Sea Link

Volume 6: Environmental Statement

Document: 6.2.1.6
Part 1 Introduction
Chapter 6
Scoping Opinion and EIA Consultation

Table 6.1 Overarching Planning Inspectorates comments raised in the Scoping Opinion

- B3: Yox Valley
- B4: Fromus Valley
- B5: Alde Valley
- D3: Minsmere and Sizewell Coast
- D4: Thorpeness to Aldeburgh
- J4: Alde Estuary
- K3: Aldringham and Freston Sandlands
- K4: Rendlesham and Tunstall Sandlands
- L1: Heveningham and Knodishall Estate Claylands
- O1: Benhall Estate Sandlands

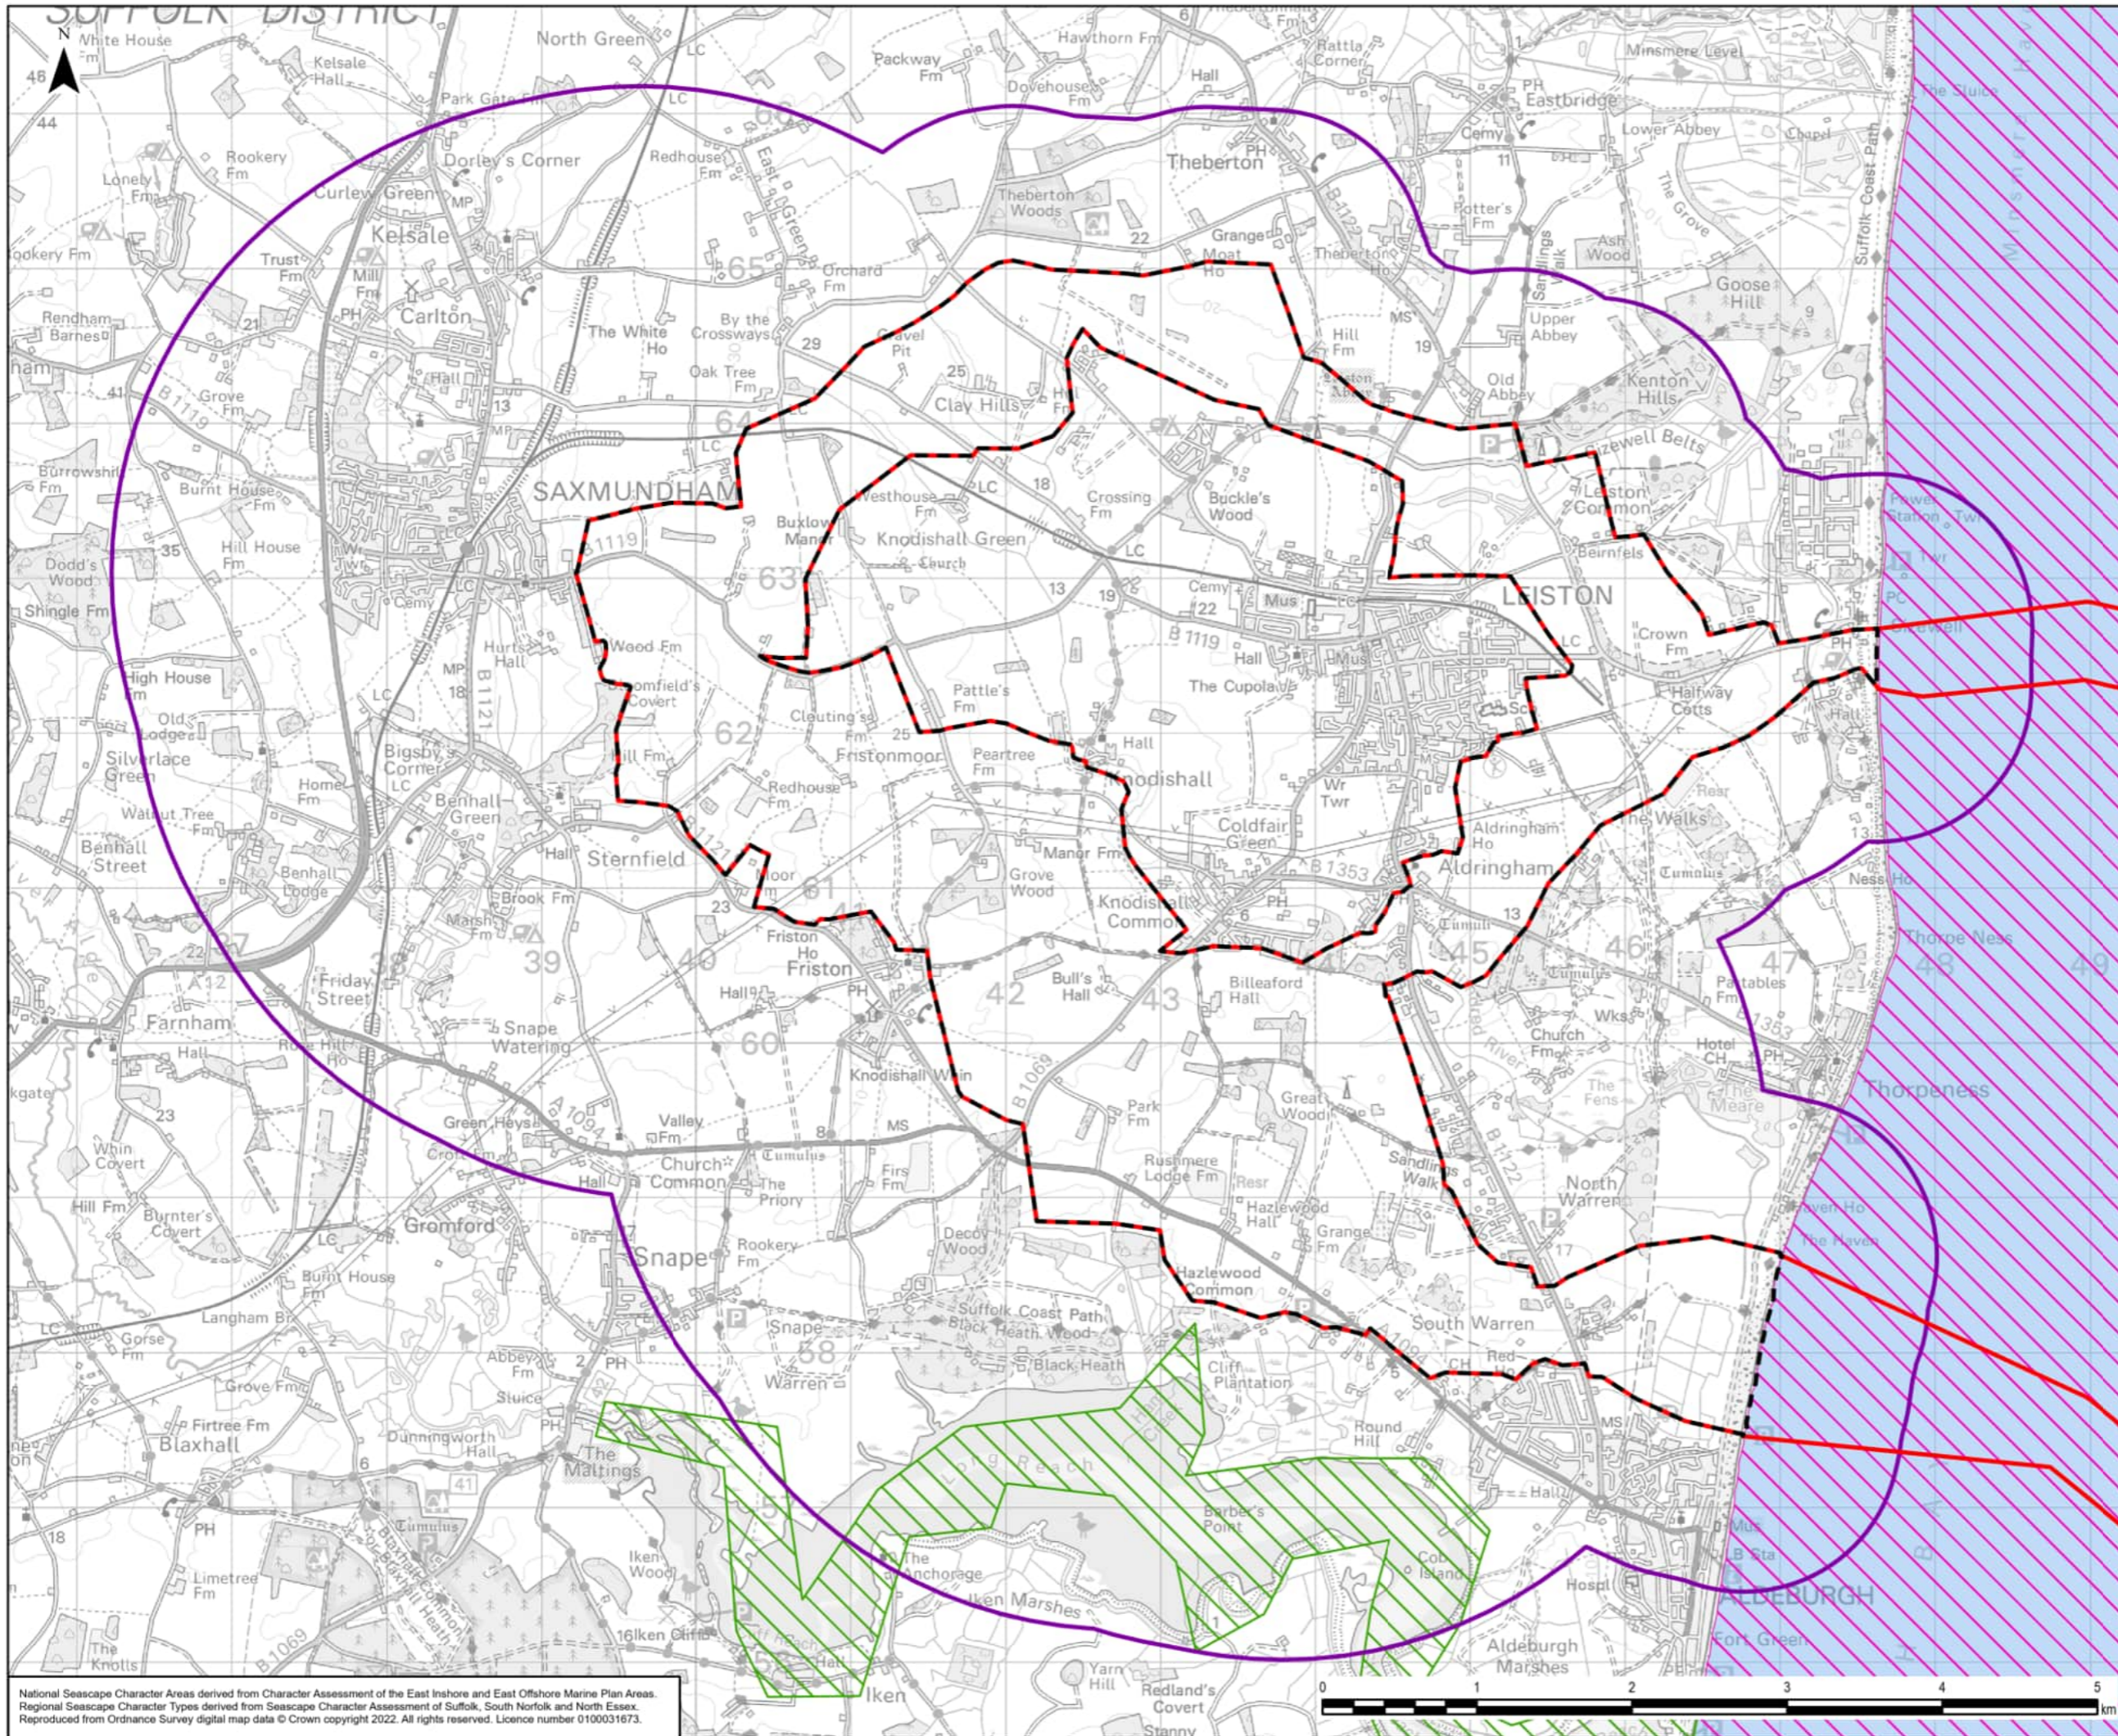
2.2.3	<p>Figures</p> <p>There are a number of Figures where the legends/keys make it difficult to distinguish</p>	<p>Noted, the figures supporting the planning application have considered</p>

varying features. For example, Figure 2.2.3 contains two hatchings of very similar colour, thus making it difficult to distinguish between the regional Landscape Character Types 0 and 16. Figure 2.11.1 is missing the legend/key and the Conservation Areas of Aldeburgh, Thorpeness, Leiston, and Saxmundham are not apparent on Figure 2.4.1, despite being included in the legend/key. The ES should include clearly labelled figures with a clear legend/key to enable interpretation of the information. legibility and have been amended where possible.
